**Consultation Response from KC Conservation and Design**

**2019/91422 2, Nelson Street, Birstall, Batley, WF17 9EP**

**Alterations and erection of rear dormer windows to convert existing building (A2) to 7 apartments (within a Conservation Area)**

**Date Responded: 19.6.19**

FRONT ELEVATION

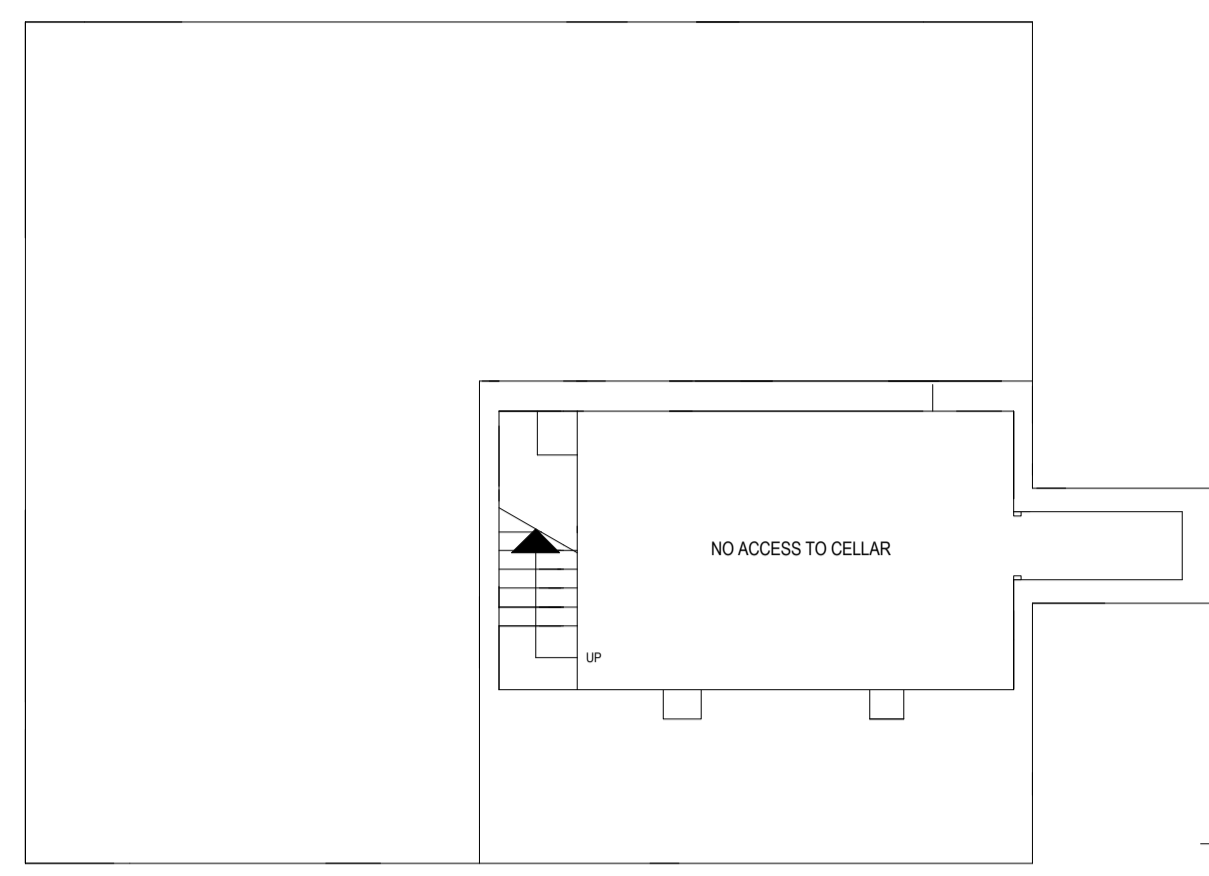
Conservation roof lights in the rear pitch are acceptable although I would prefer them to be omitted from the front pitch. An alternative may be to insert high level windows into the gables if this is possible.

The addition of two ground floor windows on the rear elevation is acceptable. No alterations are proposed to the fenestration on the façade, although I would support the replacement of the existing windows with new double glazed timber sash windows where possible if the applicant wishes to add this to the proposal.

The heritage statement indicates that the front area will be landscaped and I would welcome improvements to the surfacing at the front of the property along with the construction of a low stone front boundary wall as this will enhance the conservation area.

FIRST FLOOR PROPOSED

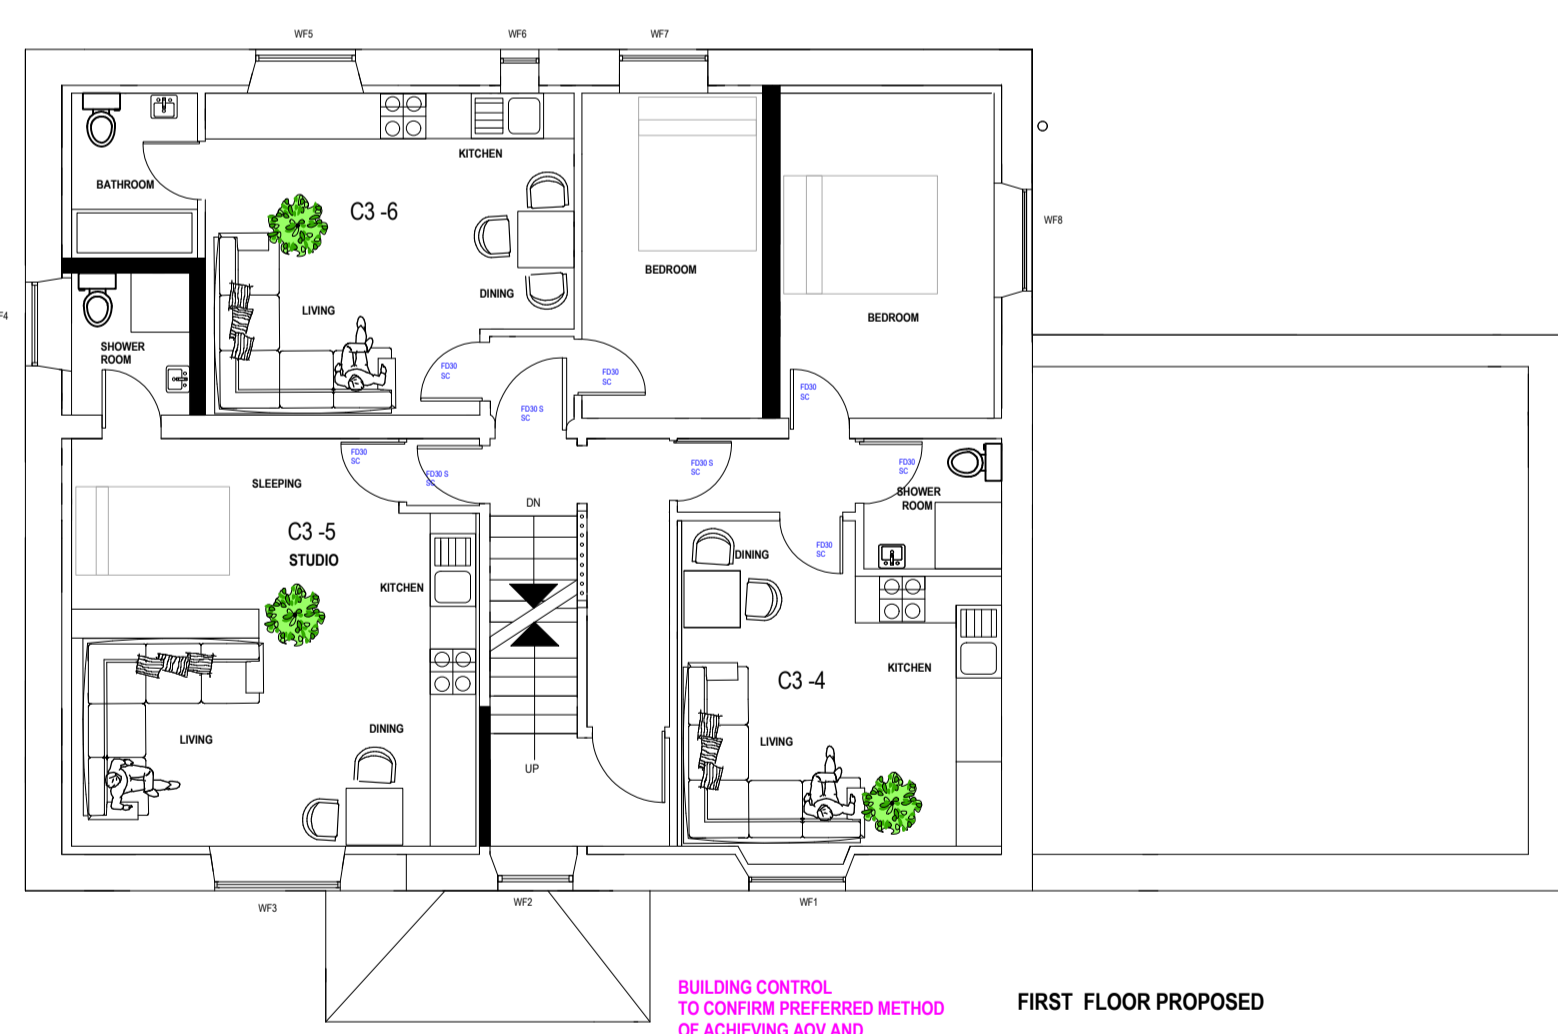
The application proposes to replace the stone slate roof to a different material, Streetscape graphite Brazilian stone slate. There is no justification for the replacement of the existing traditional roof covering which I consider to add to the character of the building. I would prefer the stone slate roof covering to be retained and if it needs to be re-roofed it should match the existing, with diminishing courses and copings, retaining the existing slates where possible and ensuring that where replacements are necessary matching slates are laid on the front roof pitch to prevent a patchy appearance. A breathable membrane should be used.

REAR ELEVATION

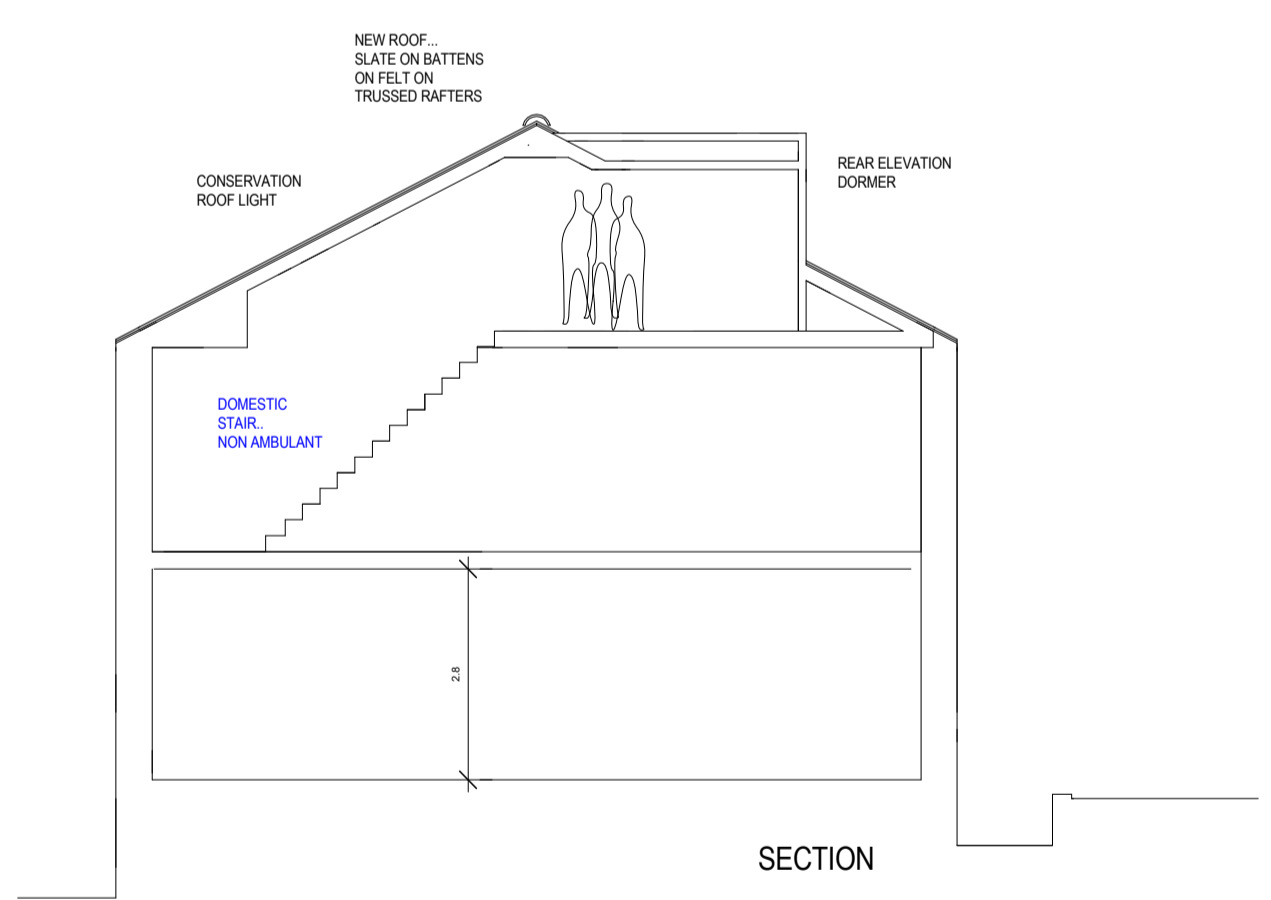
I have no objections in principle to new dormer windows, clad in traditional slate tiles to match the existing, being constructed on the rear roof pitch as this is a less prominent elevation. I would suggest that the two dormers are the same size, perhaps with the internal layout reconfigured.

Car parking and bin storage to the rear is acceptable as this does not affect the character of the conservation area.
